West Sussex County Council - Planning Consultation Response

LPA Reference: AL/63/26/DOC

Location: Land West Of Ryefield Farmhouse

Proposal: Approval of details reserved by condition under AL/31/22/PL relating to Condition 4 - External Materials & Finishes; Condition 8 - Hard & Soft Landscaping; Condition 9 - Construction and Biodiversity Management Plan and Condition 10 - Broadband Provision.

Drawn BTM	Date: 29/09/2026	Scale (at A3) 1:200
Drwg no. RFW/SR/8001	Revision No. A

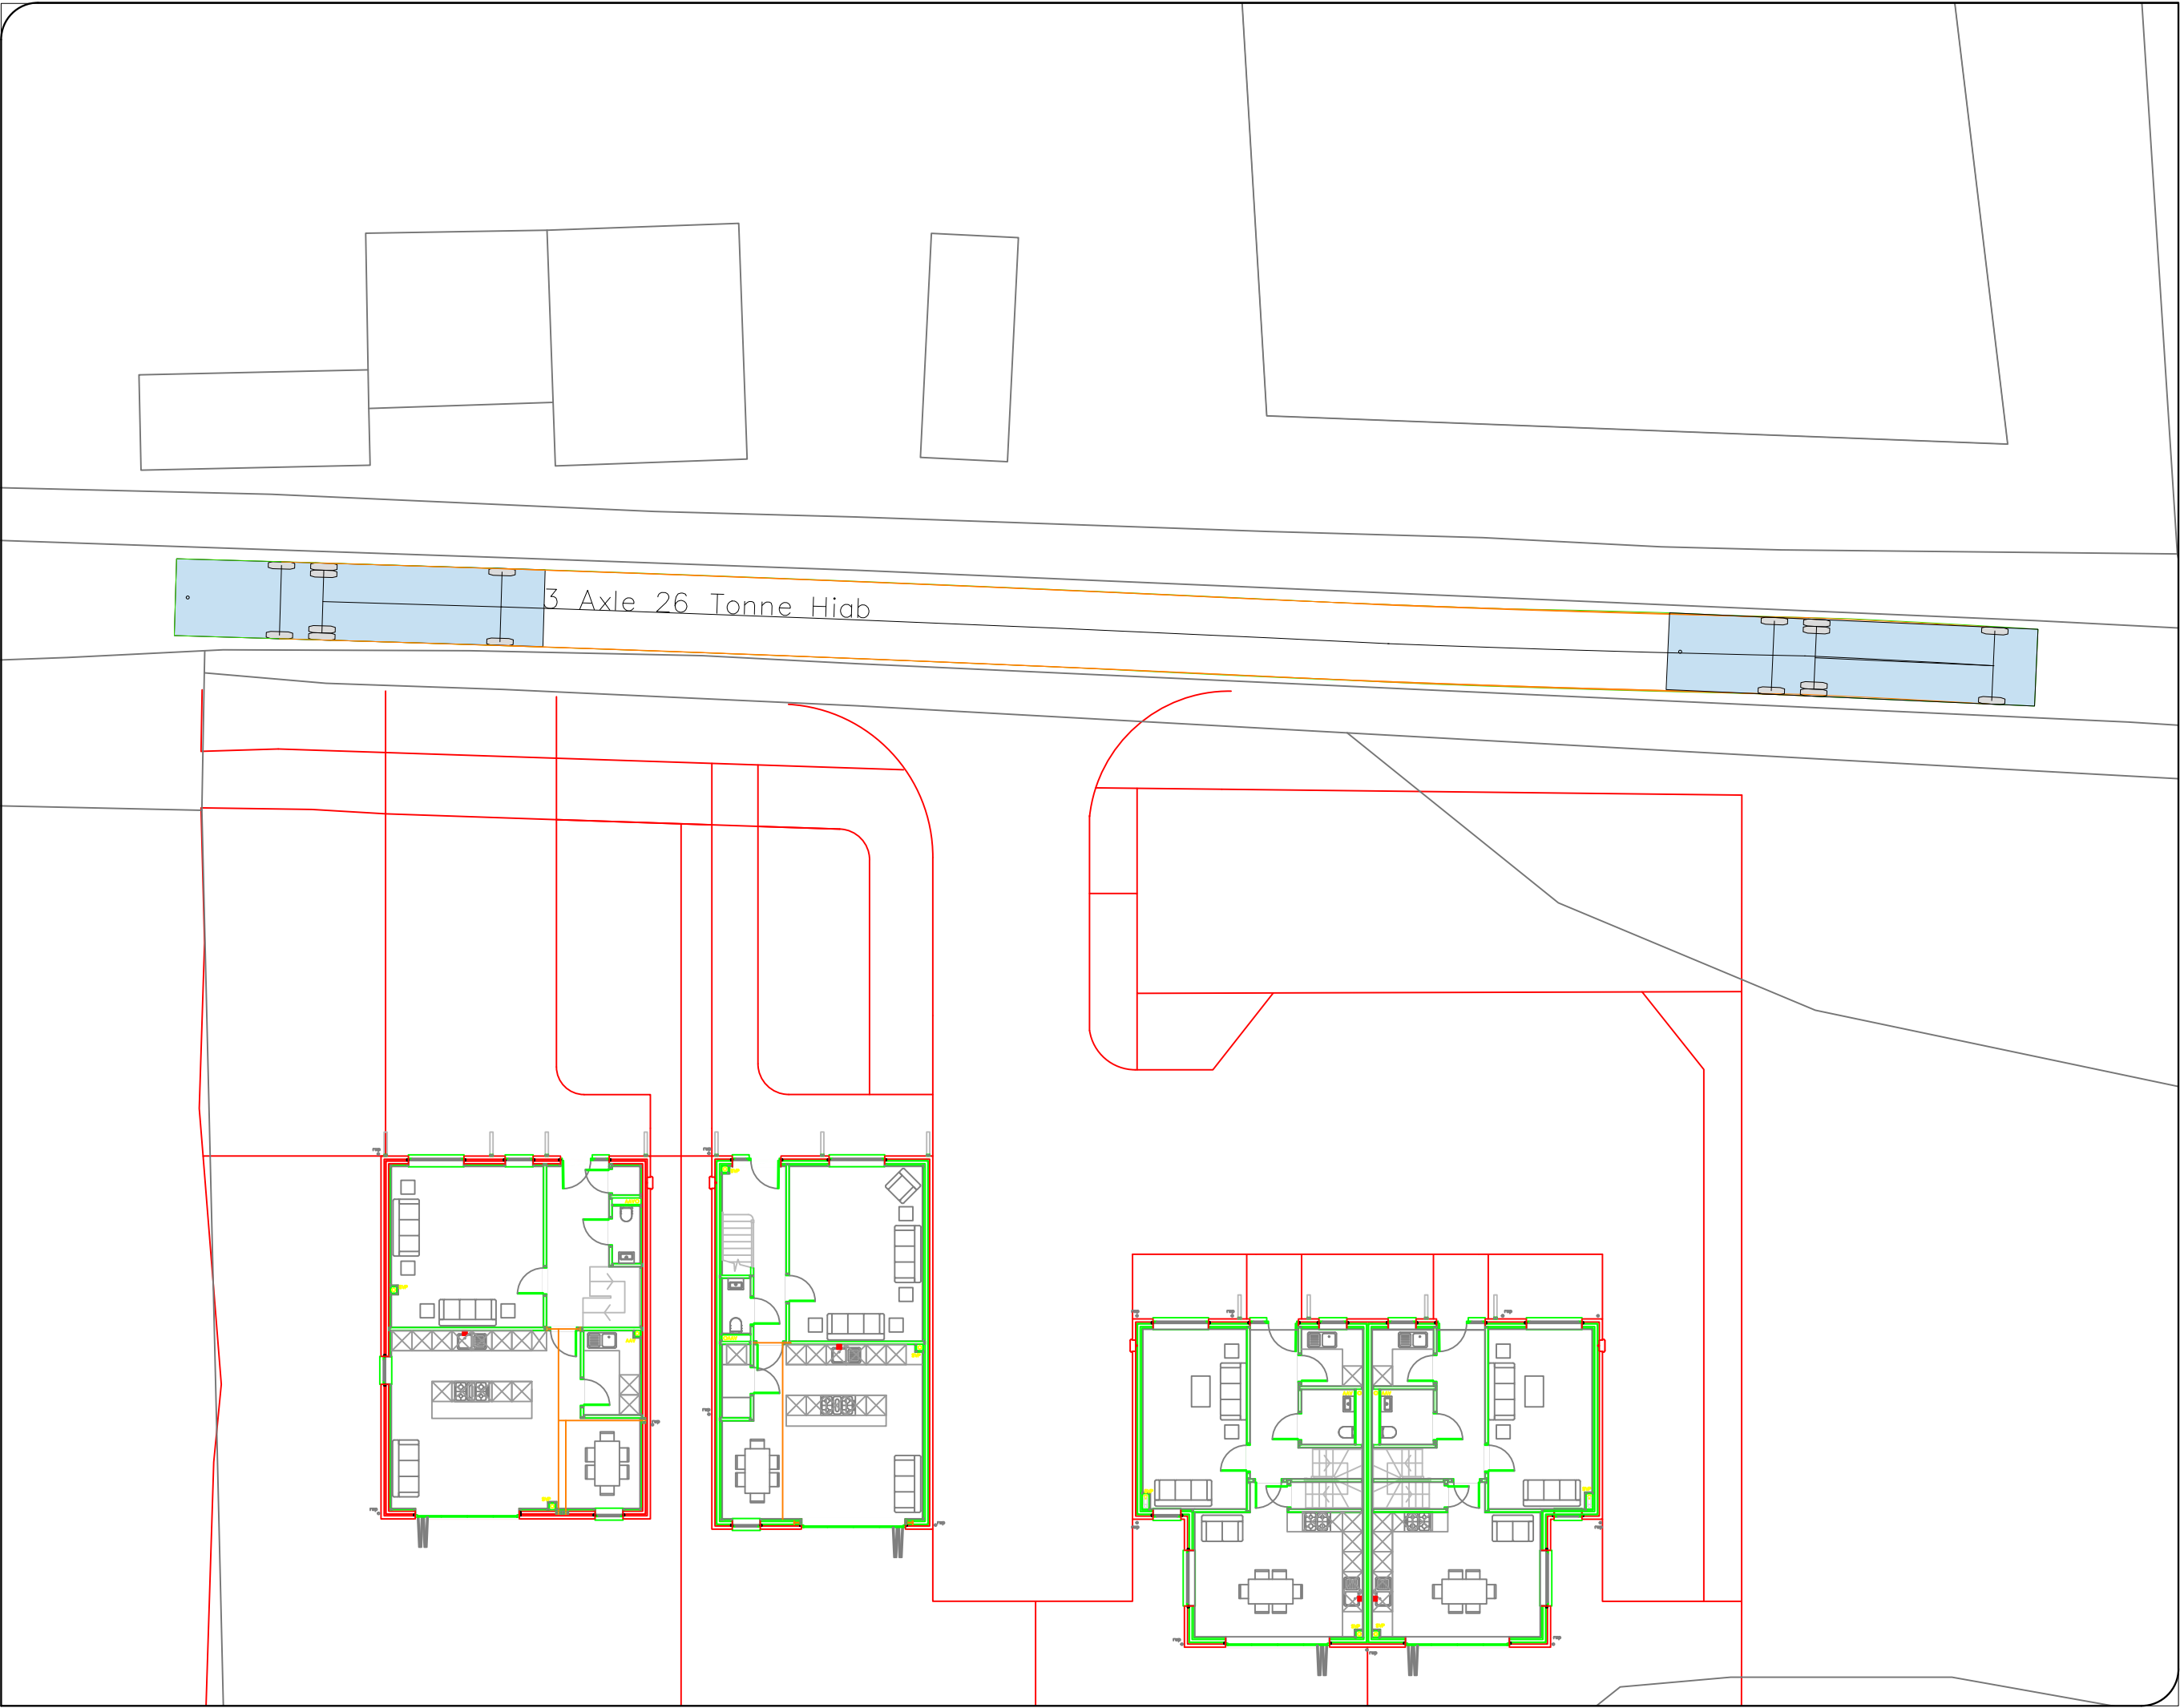
The outstanding point needing further information from the applicant was the latter half of point 2 above, namely plans to show how delivery vehicles would be able to turn within the site.

In response to this, the applicant has provided the following additional information that shows how a selection of large vehicles should be able to turn within the site and, thereby, leave in a forward gear (and only needing to reverse into the site as it/they arrives, which should be assisted by a banksman).
